From: Alistair Dodd [REDACTED]
Sent: 08 June 2017 10:36
To: Anita Gardner
Cc: Sue Howell; 1stforlofts@gmail.com
Subject: RE: A/64/17/DOC 1-6 The Cottrells, Angmering

From: Anita Gardner [mailto:Anita.Gardner@arun.gov.uk]
Sent: Friday, May 26, 2017 2:28 PM
To: 'Alistair Dodd'
Subject: RE: A/64/17/DOC 1-6 The Cottrells, Angmering

Rev	Description	Date
Job Reference		Client
New House The Cottrells Angmering		AM Homes Ltd
Drawing Title		Drawing No
Hard & Soft Landscaping Plan		AD962/02
Date	Scale	Dwg Size
26.02.17	1:100	A3
Plot Style	Drawn	Checked
ADG/ryc/sk	TGG	AD

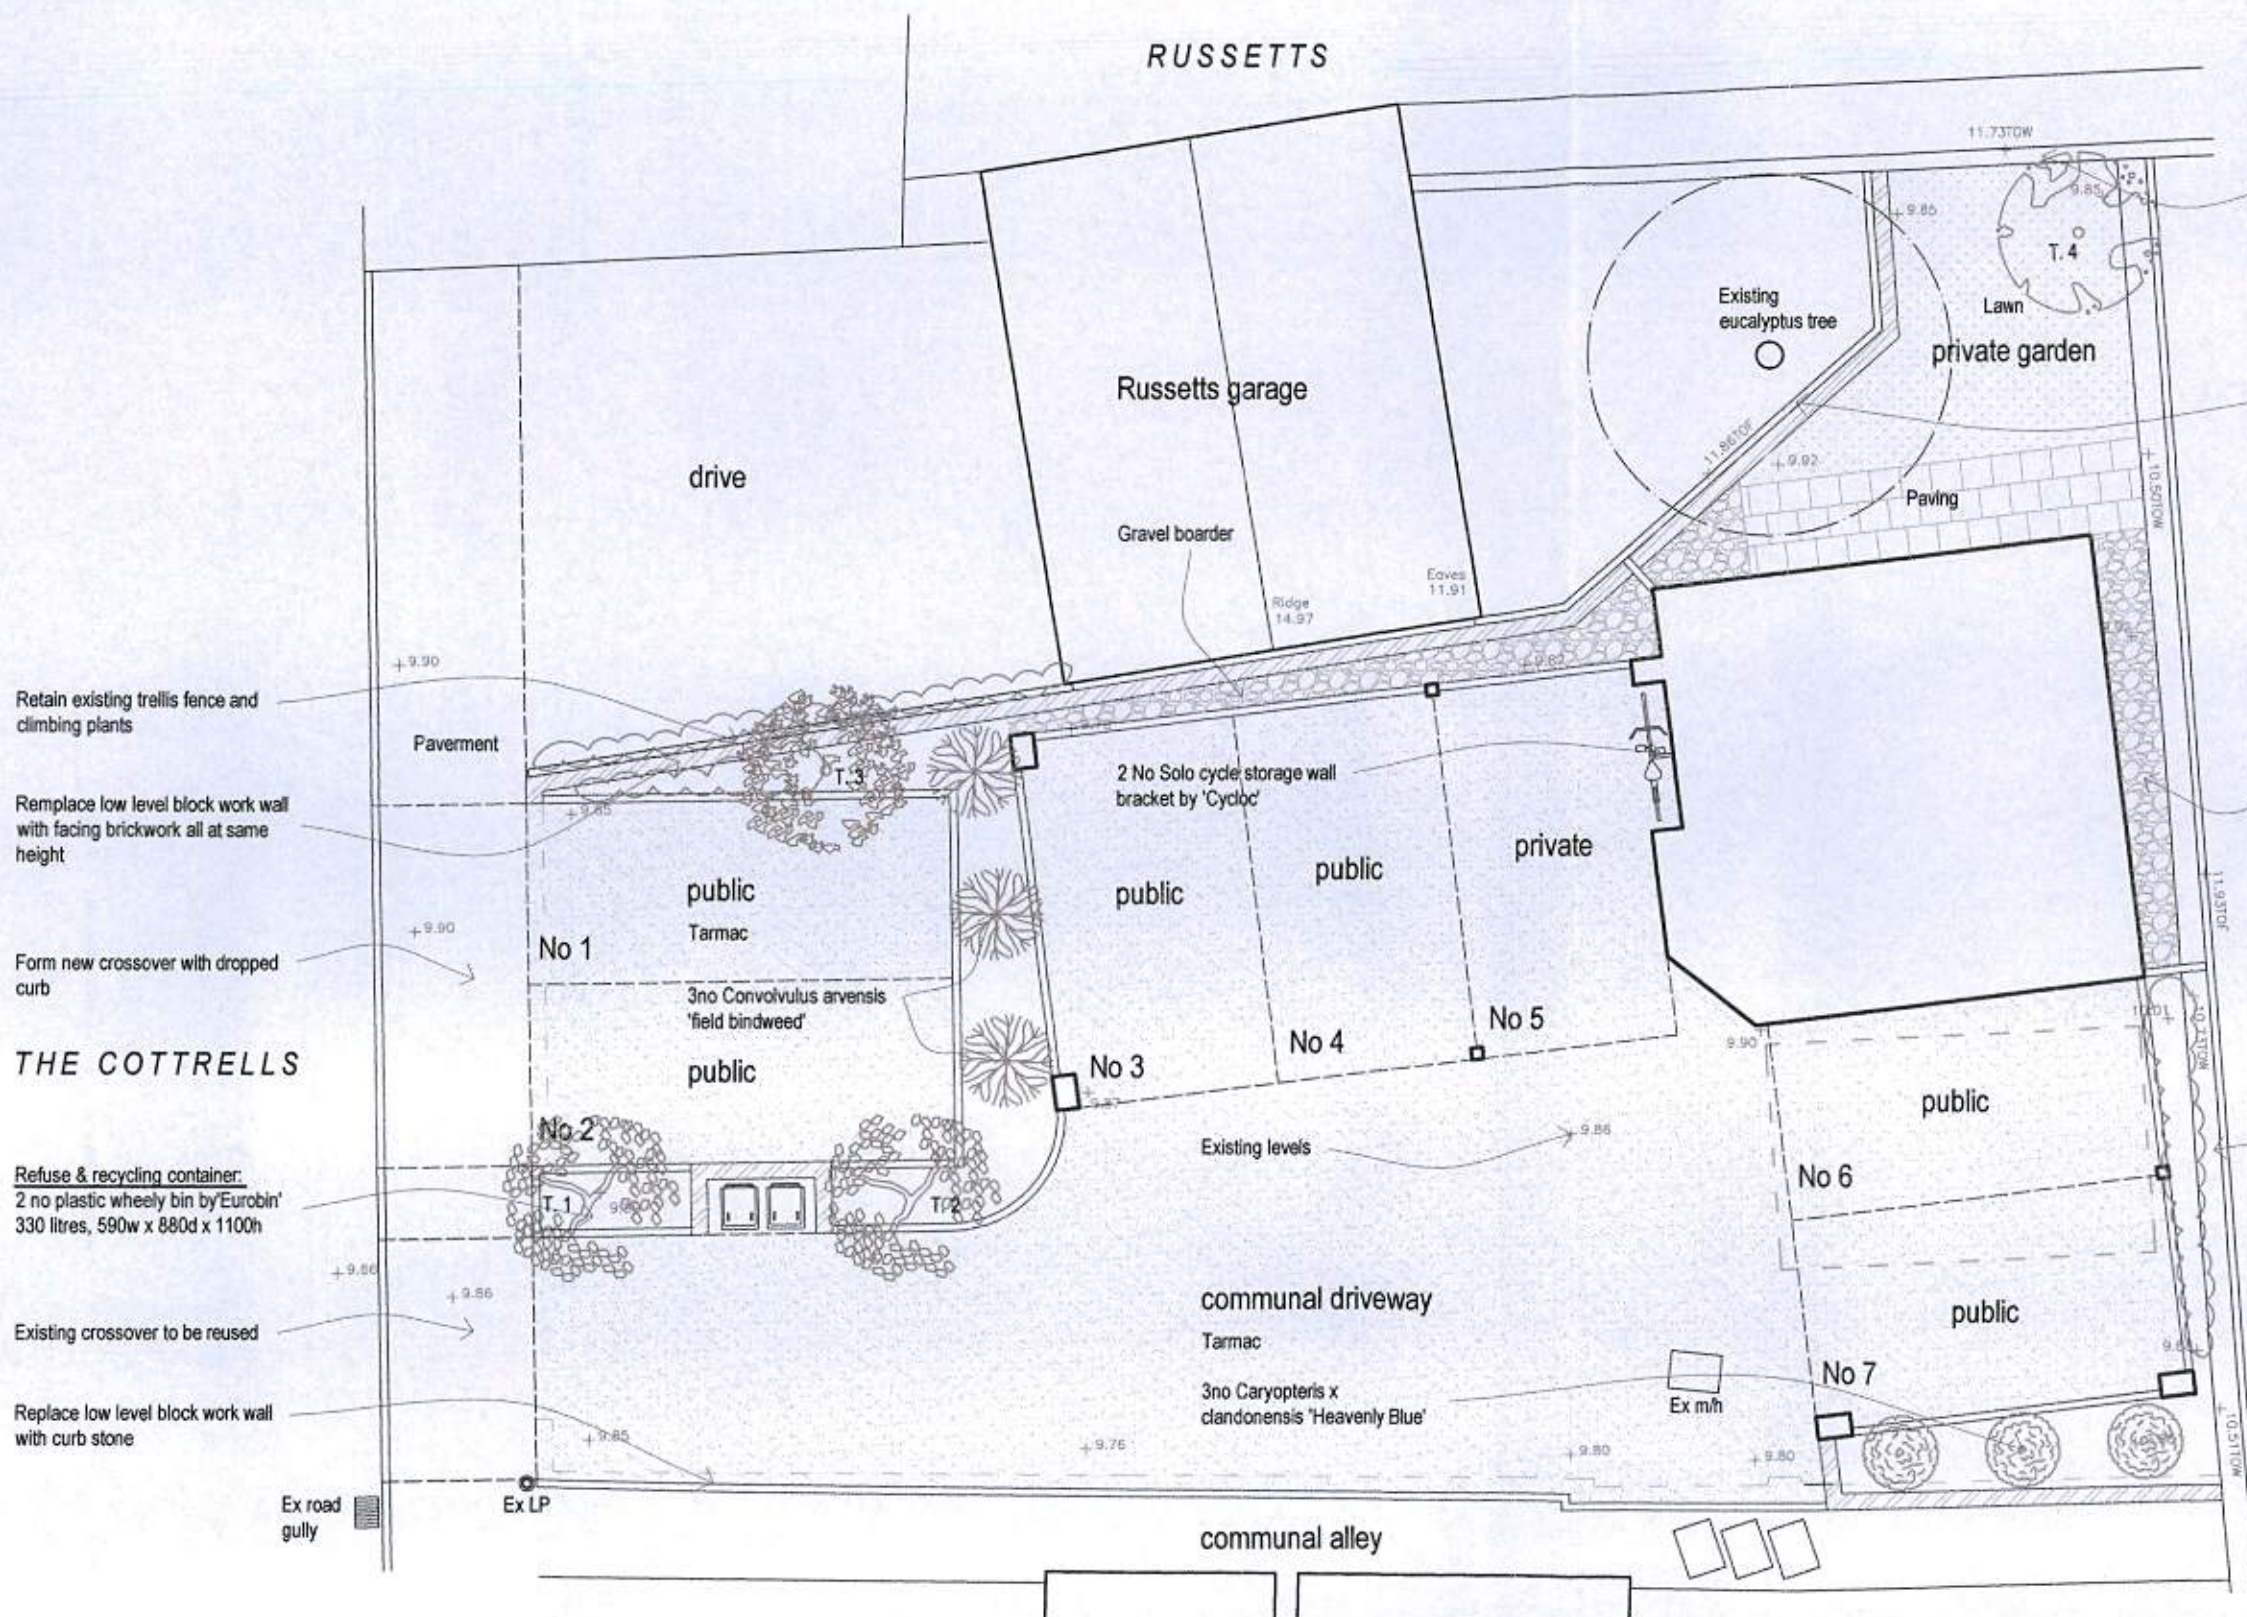
In addition I have subsequently received the comments of the Conservation officer who has stated that some of the materials specified on the 'External Materials List' submitted to discharge the condition (A/64/17/DOC) are consistent with those approved under A/105/16/PL. However, there are a number of deviations:

Windows and doors: timber

Aluminium

Driveway: block paving

Tarmac

The permitted building is of traditional scale, form and style and it is located in the Angmering Conservation Area. In a context such as this, the use of good quality, traditional materials is expected and the various modern materials now proposed as alternatives are entirely alien to the context.

I would therefore appreciate further amendment of the submitted details to accord with those approved under A/64/17/DOC. To allow time for receipt of this additional information I request written confirmation of your agreement to an extension of time on the application until 19-06-2017.

Thank you for the email and further to my discussion with Sue Howell please find attached our revised landscape drawing No ADC 962/02A, External Materials List Rev B, Photograph sample of paver and the Landscape Method Statement by Aspen Tree Care.

Landscaping: Three shrubs species have been changed as discussed with Ms Howell and as advised by Aspen Tree Care method statement.

Materials: I confirm the dark stain for the weatherboarding is black. The windows and doors have been changed to grey painted timber and parking forecourt material changed to charcoal colour Driveline Priora block paving.

A		Flatbed delivery lorry added		04.05.17	
Rev		Description		Date	
Job Reference			Client		
New House The Cottrells Angmering			AM Homes Ltd		
Drawing Title			Drawing No		
Site Works Plan			AD962/03		
			Rev		
			A		
Date	Scale	Dwg Size	Plot Style	Drawn	Checked
28.02.17	1:100	A3	AD09xscale	TCG	AD

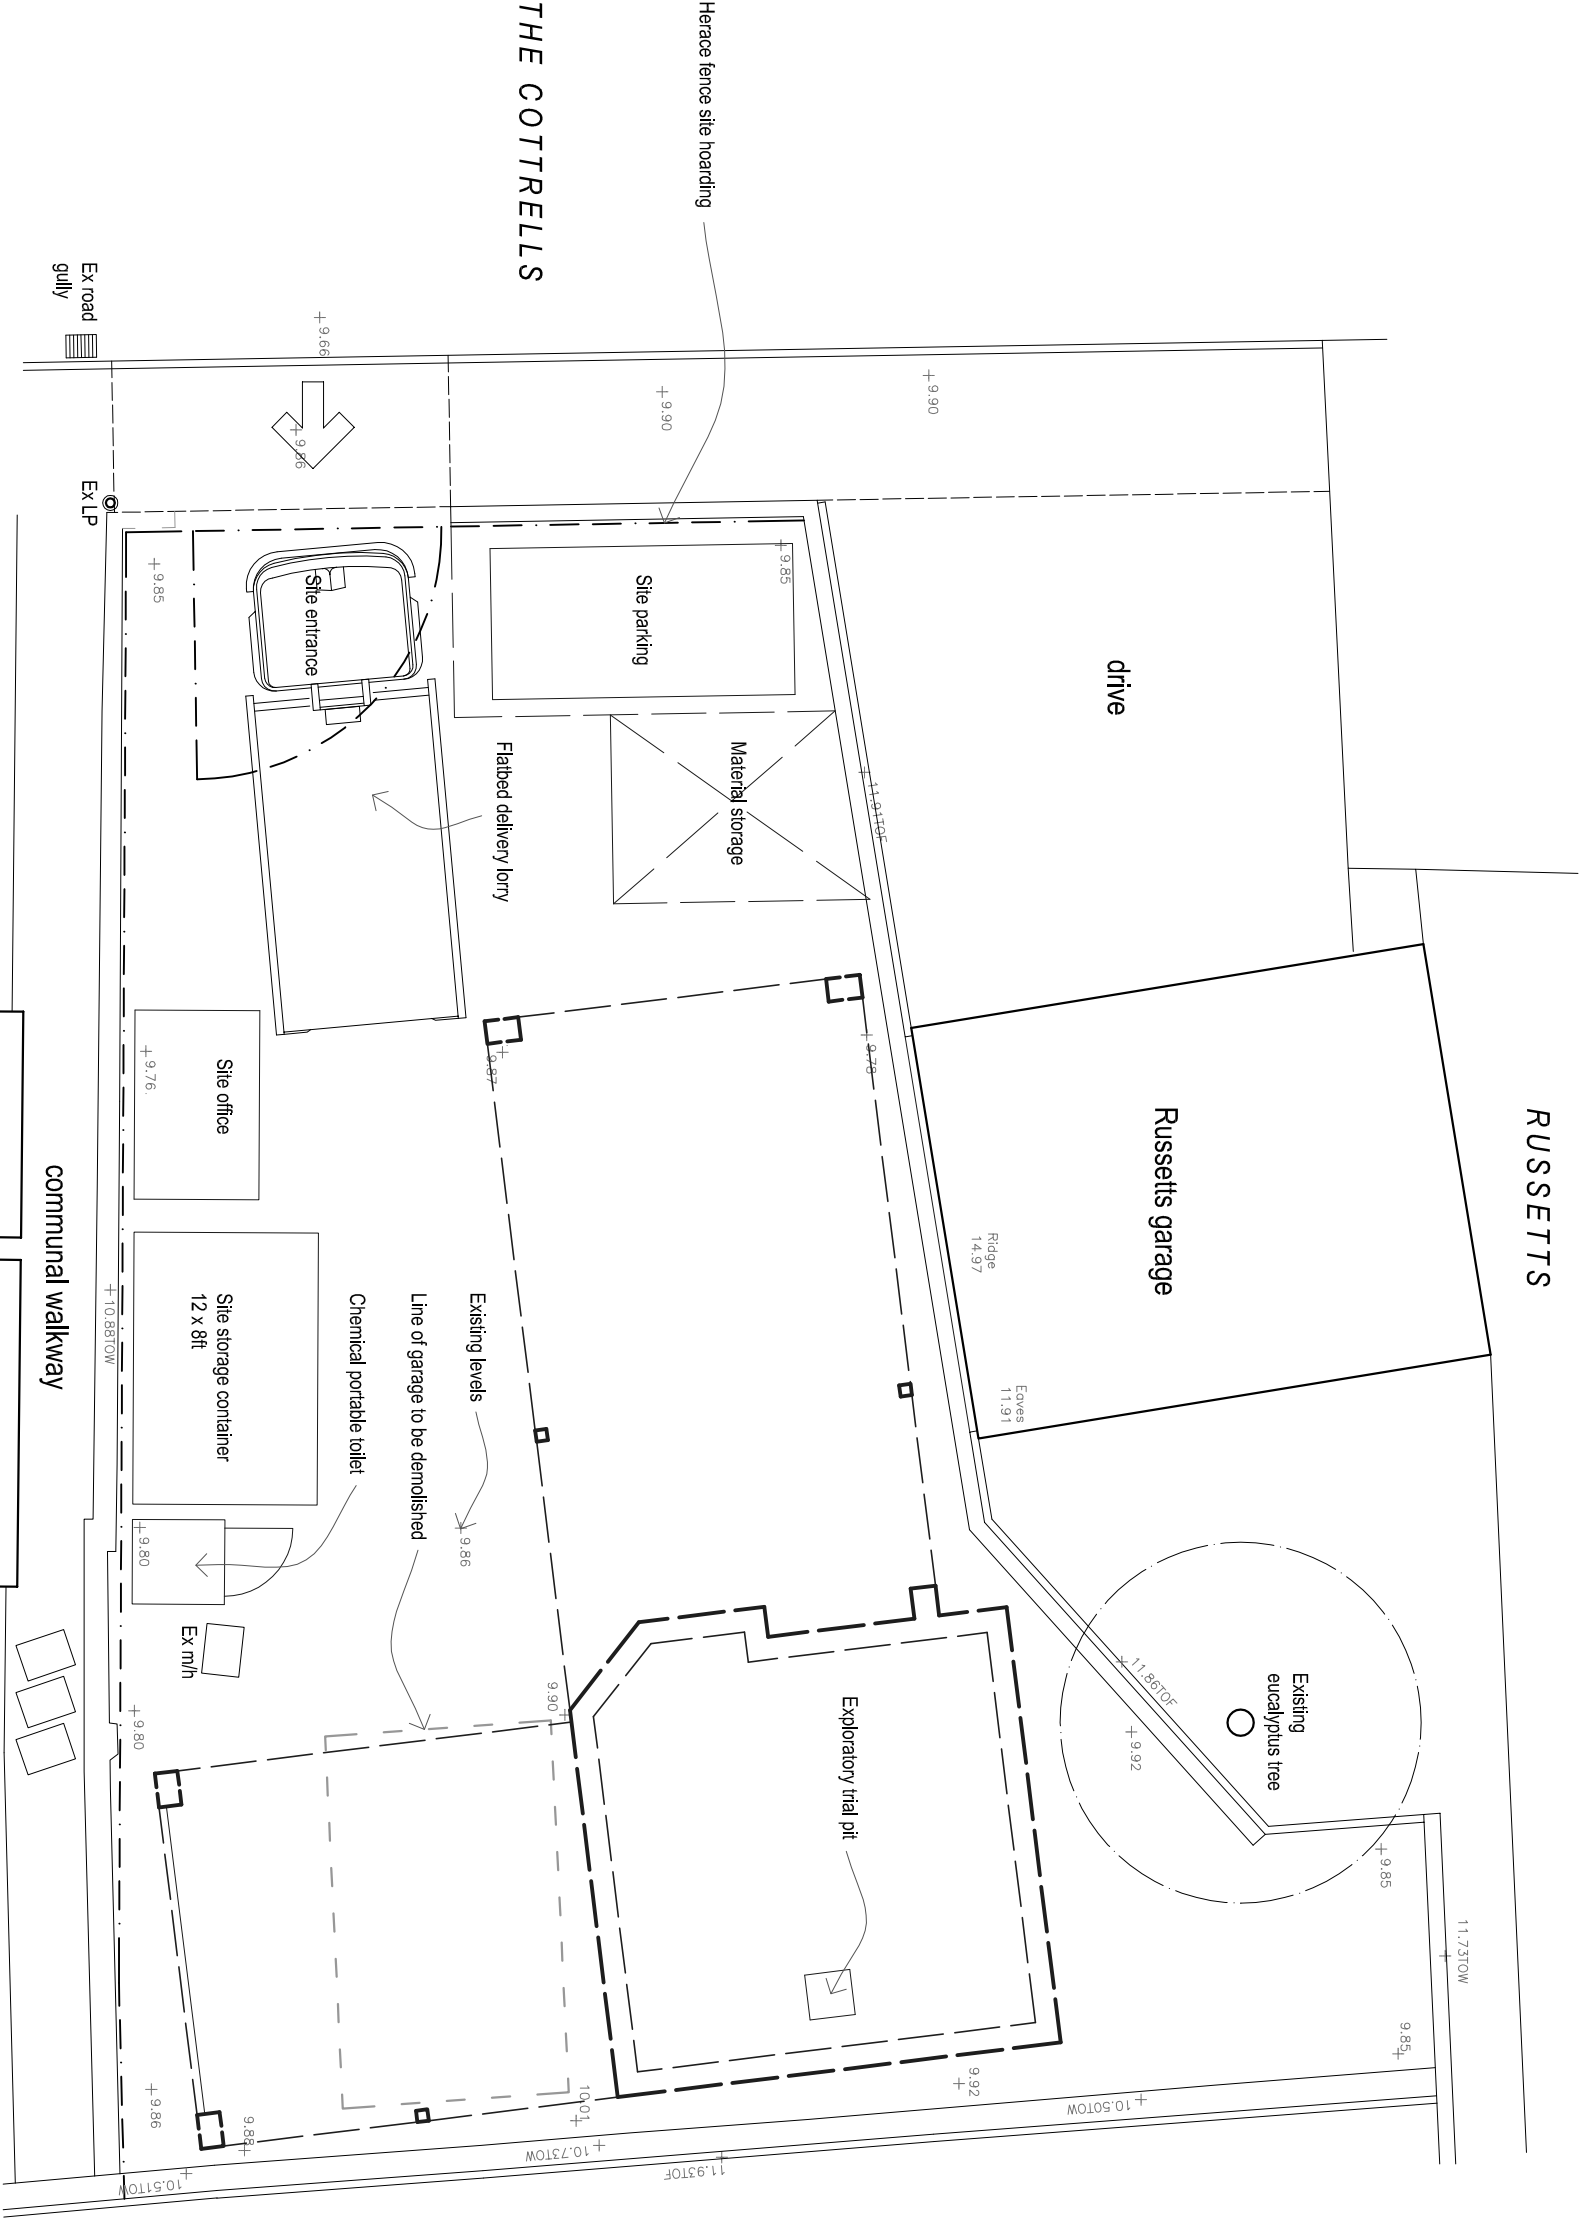
Thanks for this, based on the revised plan (AD962/03 A) the applicant has demonstrated how a flatbed delivery lorry could be facilitate on site. It is clear from this plan that such a delivery lorry would not be able to turn on site. I would therefore recommend an annotation on the plan detailing that any reversing movements into or out of the site by construction vehicles are undertaken with the use of a competent banksman.

It is appreciated that some deliveries may need to be undertaken from the roadside.

Subject to the above amendment I would be minded to accept that that plans and details provided pertaining to condition 5 of A/173/16/PL are now acceptable from a highways perspective.
